RE: Case ID: PAE-14 Major Projects – New Request for Advice

Re: State Significant Development – Qantas Flight Training Centre

Request for SEARs – Qantas Flight Training Centre – 297 King Street, Mascot – SSD 10154

Figure 23. King Street set back

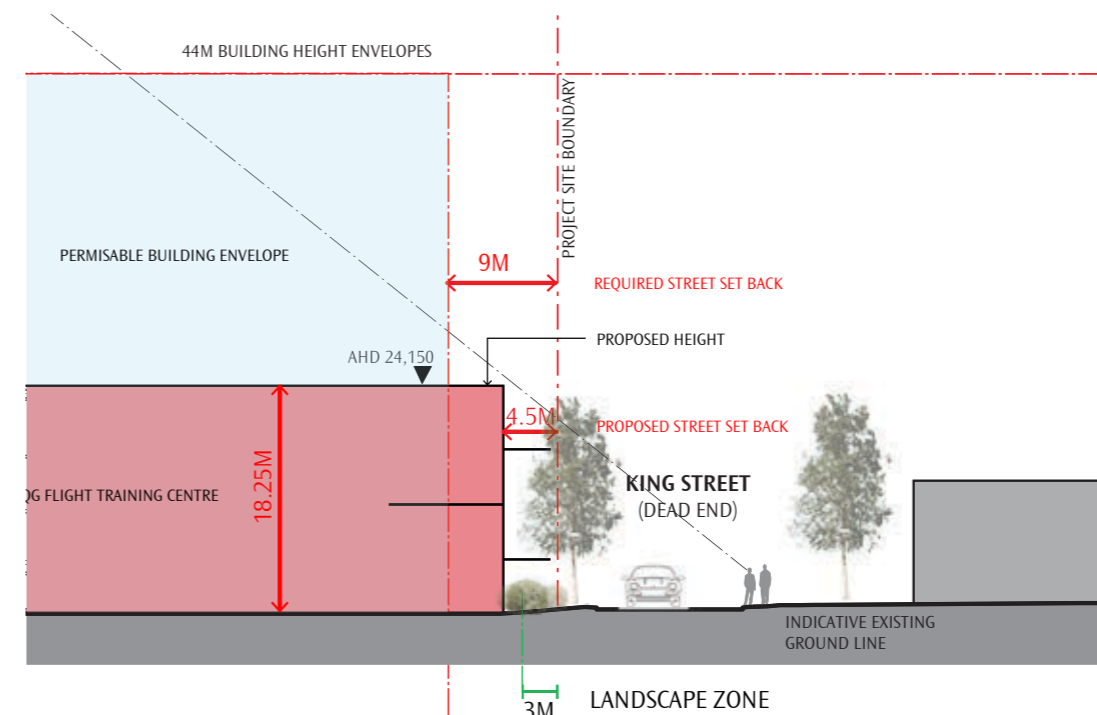
4.5 metre building setback to King Street:

The proposed location of the flight training centre results in a 4.5 metre setback to King Street. Whilst Council notes that the Botany Bay DCP 2013 does not apply to the development under clause 13 of *State Environmental Planning Policy (Stage and Regional Development) 2011*, Council recommends that a 9 metre setback along King Street be provided to align with the neighbouring site at 289-293 King Street, which was approved with a building setback ranging between 7 and 9 metres. Council may consider a reduced setback within the site adjoining the internal drop off road.
